Consultation Response from KC Highways Development Management
2019/93591 115, Northway, Mirfield, WF14 0LT
Demolition of side extension and erection of attached dwelling
Date Responded: 12/12/19 Responding Officer: CNB Responding Ref: K10-7SE/11

LOCATION PLAN

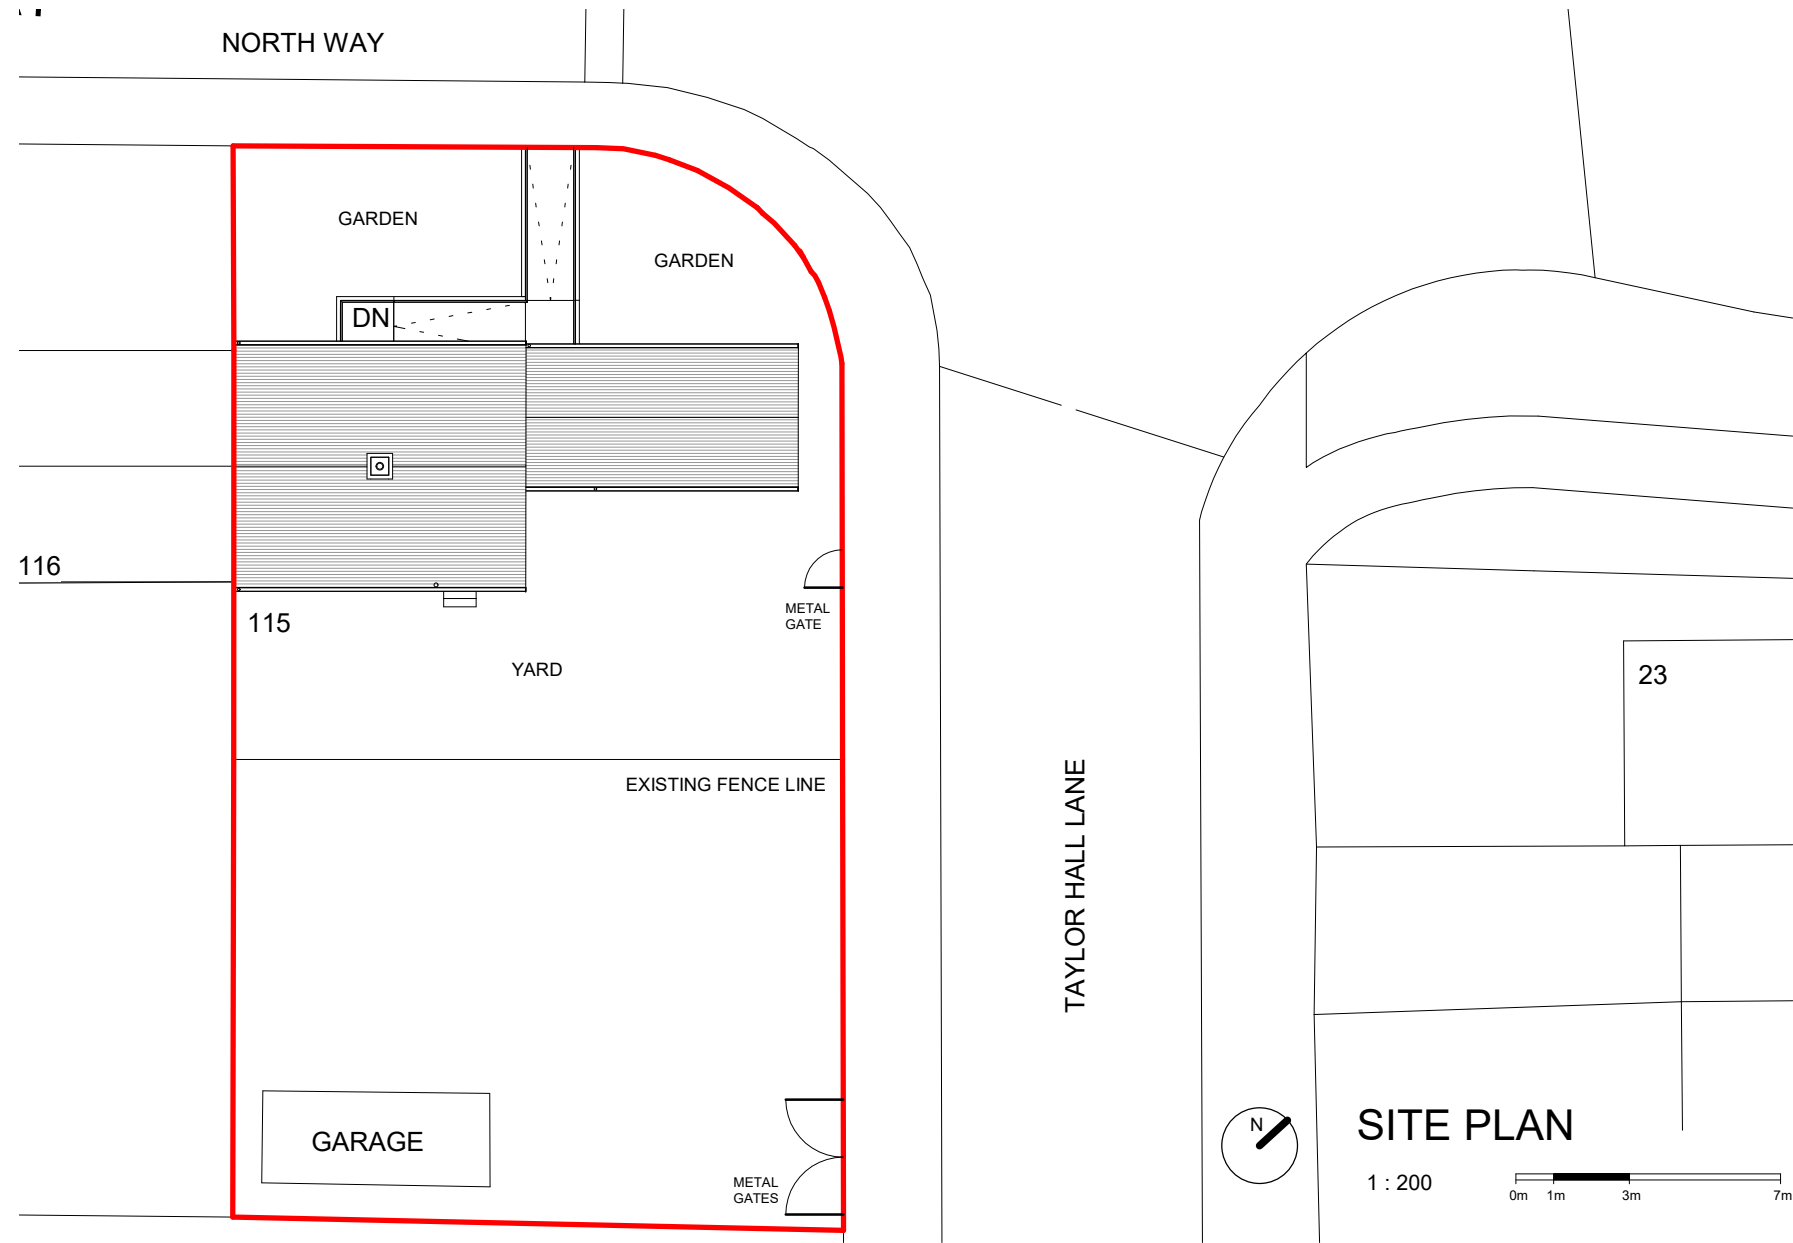
The access is existing but would experience an intensification of use with the proposals. Visibility splays of 2.4m x 43m (suitable for a 30mph road) were shown on drawing 002, these are acceptable.

The access is shown with the existing gates retained, we would prefer that the gates were removed or set back a distance of 5m behind the back of the adopted highway. This would allow a vehicle waiting for the gates to be opened to pull clear of the highway/footway so as not to cause an obstruction. The gates should also be hung so as to open inwards only for highway safety reasons. This should be conditioned.

In order to be viewed as being fit for purpose we would be looking to see two parking spaces per dwelling and this was recommended in the pre-application advice. Drawing 002 shows 3 parking spaces plus one "additional parking space", however this additional parking space would block the access for the original three parking spaces and so is not acceptable.

The application should clearly show that two off street parking spaces per dwelling can be provided and this should be conditioned due to the narrow highway width to the front of the dwellings. There appears to be sufficient space within the site to allow the four parking spaces.

No waste collection details were provided with the application although these were requested in the pre-application advice. The location of a refuse/recycling collection point should be clearly indicated on a drawing and should be located where it is accessible to a cleansing operative but not where it would obstruct wither the access or parking spaces or the adopted footway/highway for road safety reasons. This should be conditioned and advice on guidance for waste collection should be included as a footnote.

Notwithstanding the provisions of the Town and Country Planning (General Permitted Development) Order 1995, (or any order revoking and re-enacting that order) any gates or barriers for or over a vehicular access or egress shall be set back 5m from the back of the footway of Taylor Hall Lane and shall be hung as to only open inwards. So long as such gates or barriers are in position they shall be retained to only open inwards.

Notwithstanding the details shown on the approved plan, no development shall take place until a scheme detailing arrangements and specification for layout and parking have been submitted to and approved in writing by the Local Planning Authority. Before any building is occupied the development shall be completed in accordance with the details shown on the approved plans and retained thereafter.

Before development commences details of storage and access for collection of wastes from the premises shall be submitted to and approved in writing by the Local Planning Authority. The approved details shall be provided before first occupation and shall be so retained thereafter.
